September 26, 2022

**Re: City of Albuquerque Capital Implementation Program
1138 San Mateo Blvd. SE
Traffic Circulation Layout
Engineer's/Architect's Stamp XX-XX-XX (L18-D045A)**

Based upon the information provided in your submittal received 09-02-22, the above referenced plan cannot be approved for Building Permit until the following comments are addressed:

C2 ENLARGED ADA RAMP
1" = 5'-0"

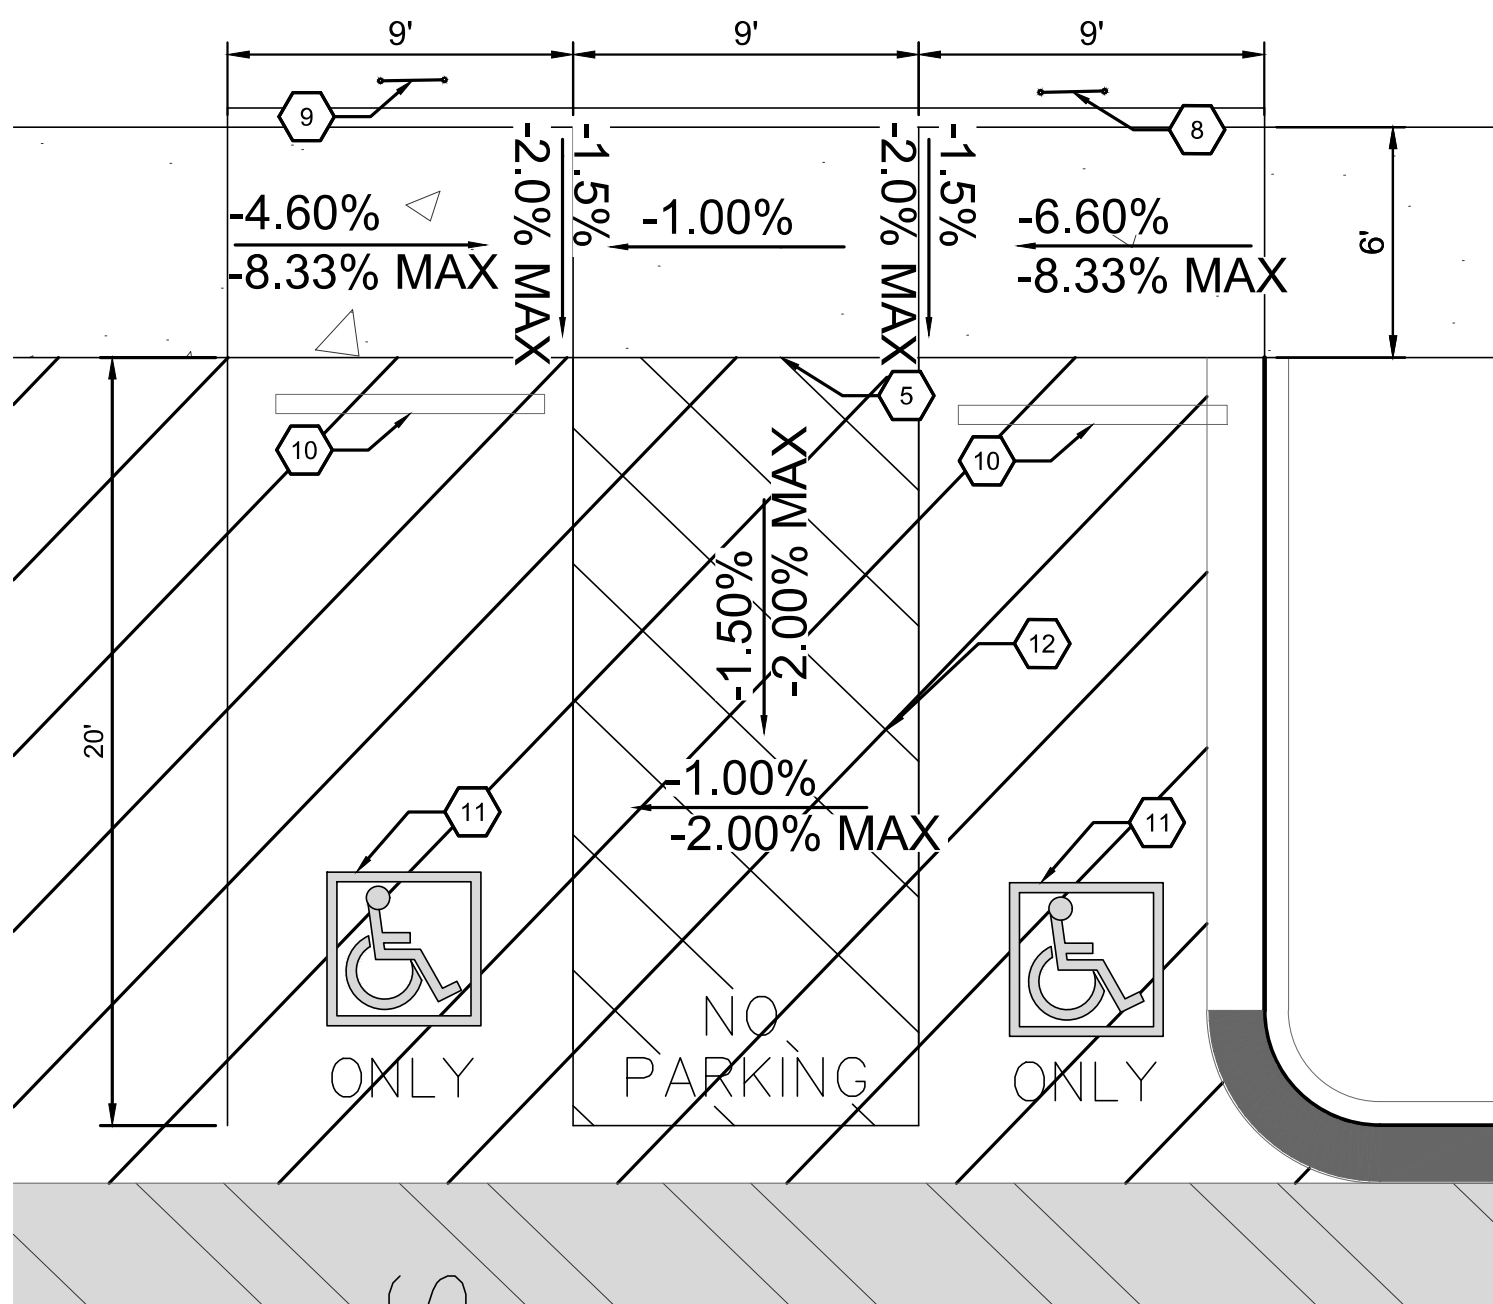
13. ADA curb ramps must be updated to current standards and have truncated domes installed.
14. Provide details for all the interior proposed ADA ramps.

A1 TRAFFIC CIRCULATION LAYOUT
1" = 30'-0"

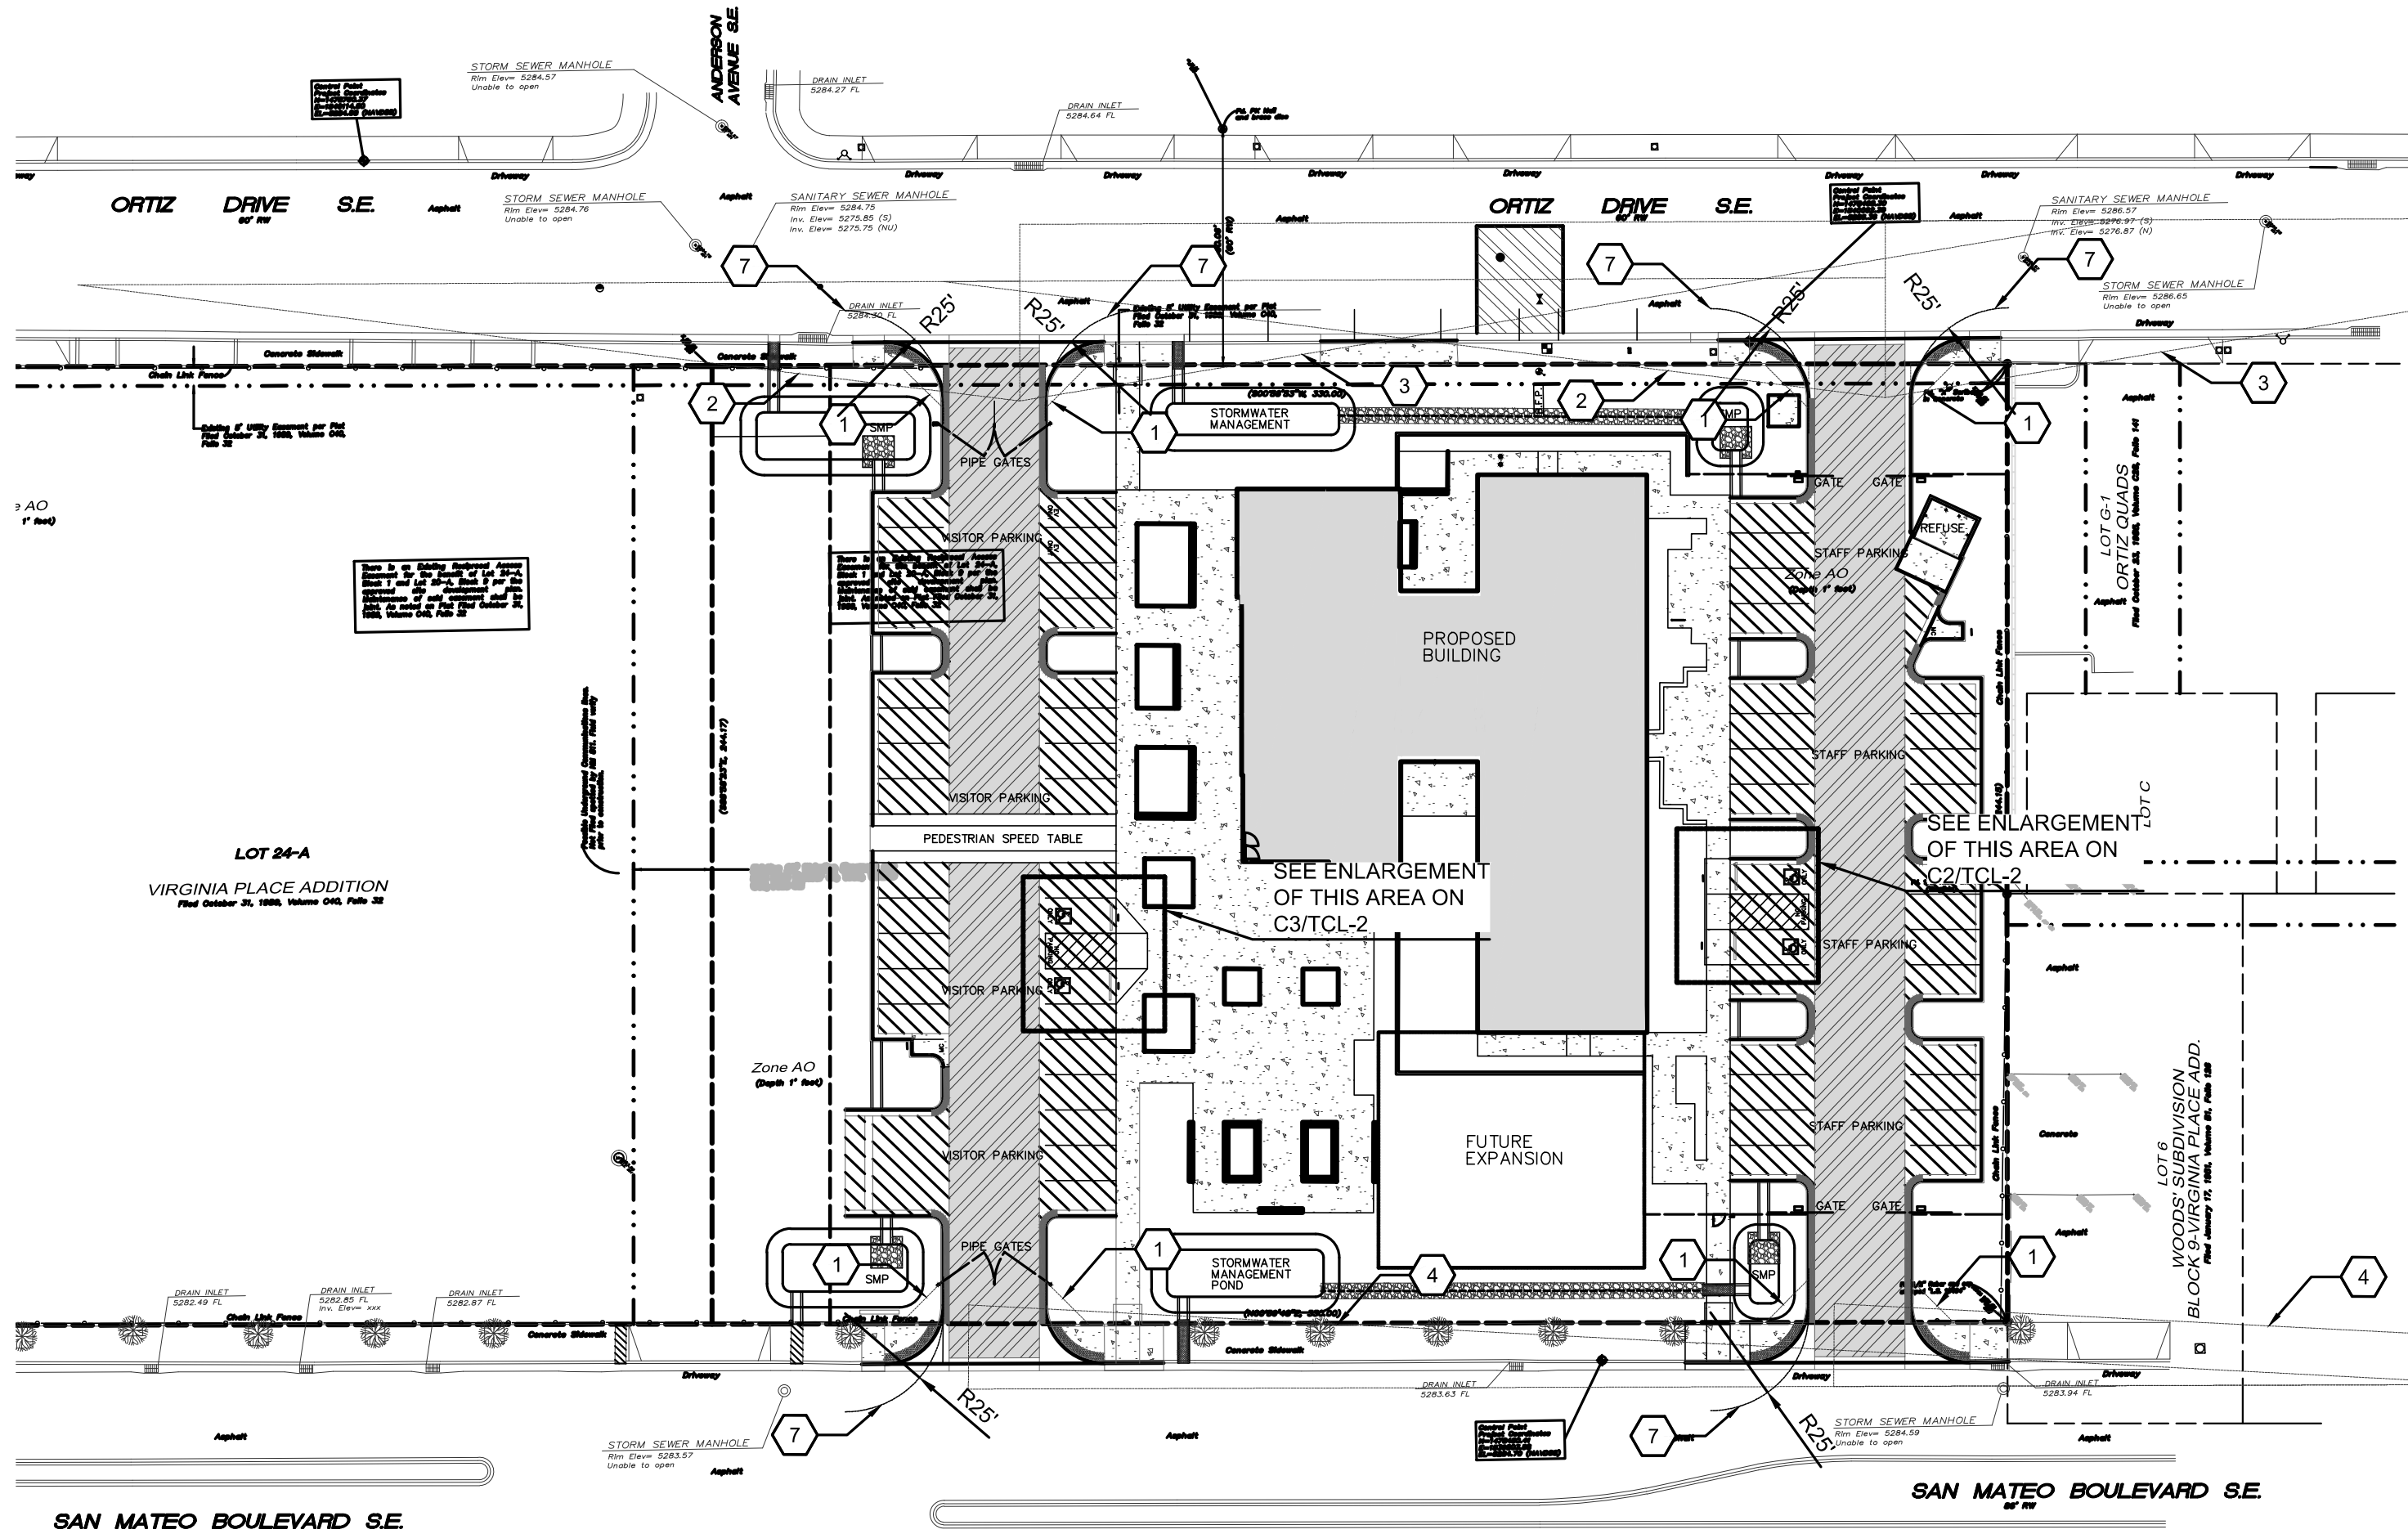
1. Please show a vicinity map showing the location of the development in relation to streets and well known landmarks.
2. List the number of parking spaces required by the IDO as well as the proposed number of parking spaces including bicycle and motorcycle parking.
3. The traffic circulation layout must be stamped, signed, and dated by an engineer or architect licensed in the state of New Mexico.
4. Identify the right of way width, medians, curb cuts, and street widths on San Mate Blvd. and Ortiz Dr.
5. Clarify existing property lines and proposed property lines.
6. All the Driveways Access off San Mateo and Ortiz should be built per COA std dwg 2426 Curb Return design.
7. Due to proposing gates, please show on the site plan Turning Movement Template.
8. Please list the width proposed parking spaces. Some dimensions are not shown.
9. The minimum parking stall dimensions are:

10. Label the compact parking spaces by placing the words "**COMPACT**" on the pavement of each space.
11. The ADA accessible spaces must include an access aisle. Van accessible aisles should be 8ft wide; all others should be 5ft wide.

12. The ADA accessible parking sign must have the required language per 66-7-352.4C NMSA 1978 **"Violators Are Subject to a Fine and/or Towing."** Please call out detail and location of signs.

15. Motorcycle parking spaces shall be designated by its own conspicuously posted upright sign, either free-standing or wall mounted per the zoning code.

16. The pavement marking "MC" should be shown in the opposite direction for Motorcycles entering the parking space.
17. All bicycle racks shall be designed according to the following guidelines:

21. List radii for all curves shown; for passenger vehicles. Radius for delivery trucks, fire trucks, etc. is 25 ft. or larger.
22. Per the IDO, a 6 ft. wide ADA accessible pedestrian pathway is required from the public sidewalk to the building entrances. Please clearly show this pathway and provide details.

23. Per DPM, a 6 ft. wide ADA accessible pedestrian pathway is required from the ADA parking stall access aisles to the building entrances. Please clearly show this pathway and provide details.

24. ADA accessible pedestrian pathway should not be placed behind parking space or adjacent to a vehicular way. Vehicle and pedestrian/wheel chair conflicts should be avoided as much as possible.

25. Curbing should be installed to delineate landscape, parking, and pedestrian ways and identify points of access. Please call out detail and location of barrier curb.

26. Parking areas shall have barriers to prevent vehicles from extending over public sidewalk, public right-of-way, or abutting lots.

28. Provide a copy of Fire Marshal Approval.
29. Please provide a sight distance exhibit
30. Show the clear sight triangle and add the following note to the plan: "Landscaping and signage will not interfere with clear sight requirements. Therefore, signs, walls, trees, and shrubbery between 3 and 8 feet tall (as measured from the gutter pan) will not be acceptable in the clear sight triangle.
